From: [REDACTED]
Sent: 03 February 2026 17:07
To: Susan Haley
Subject: RE: K/23/25/HH - Cloudy Bay, Gorse Avenue
Attachments: FRESH Architects_Cloudy Bay_Boundaries.pdf

‘Extensions to the ground, first and second floors. Removal of existing roof and replacement with a flat roof. Changes to existing fenestration. New front and rear boundaries. Renovation and extension of existing garage. Installation of an air source heat pump and air conditioning units.’

I have begun looking at application K/23/25/HH and would appreciate clarification on the following.

**Proposed Site Plan**

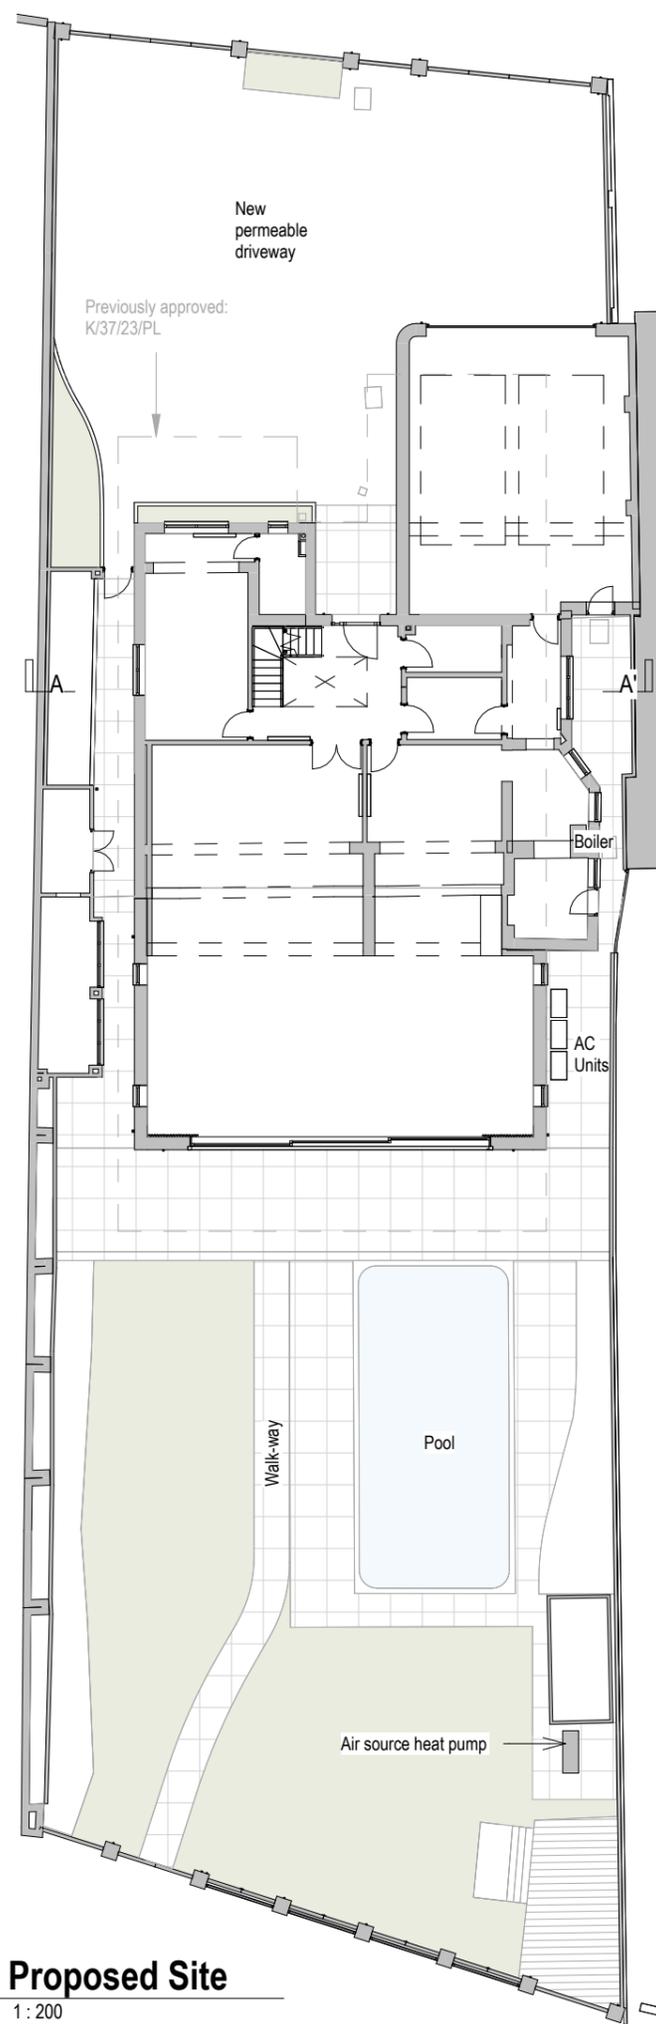
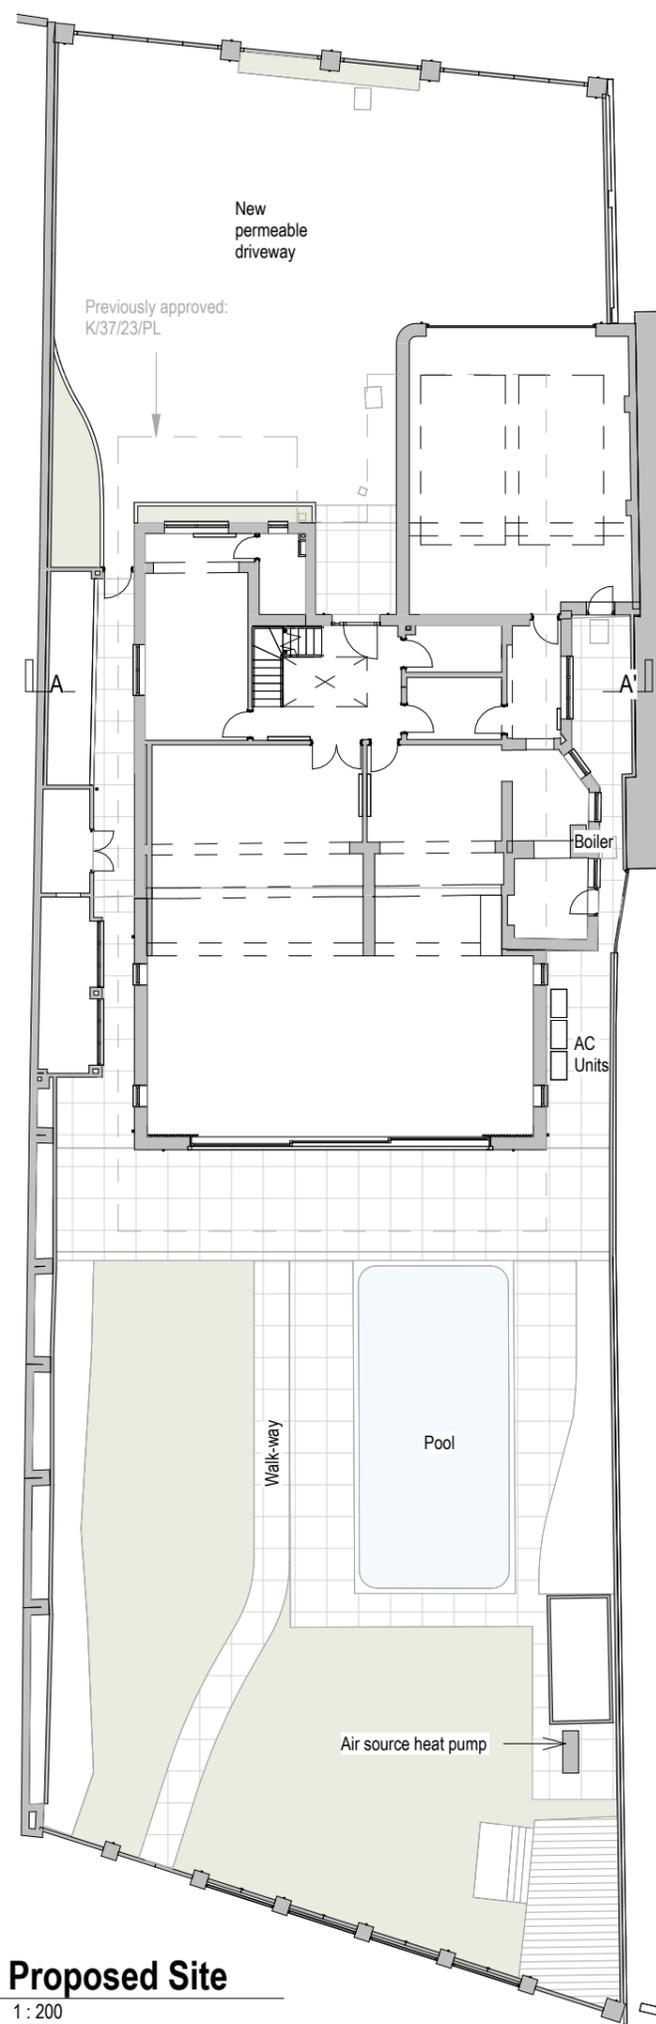
Please find attached amended proposed front boundary to remove the pedestrian gate following conversations with the Kingston Gorse Estate and retain more of the grass verge which we hope will be acceptable,
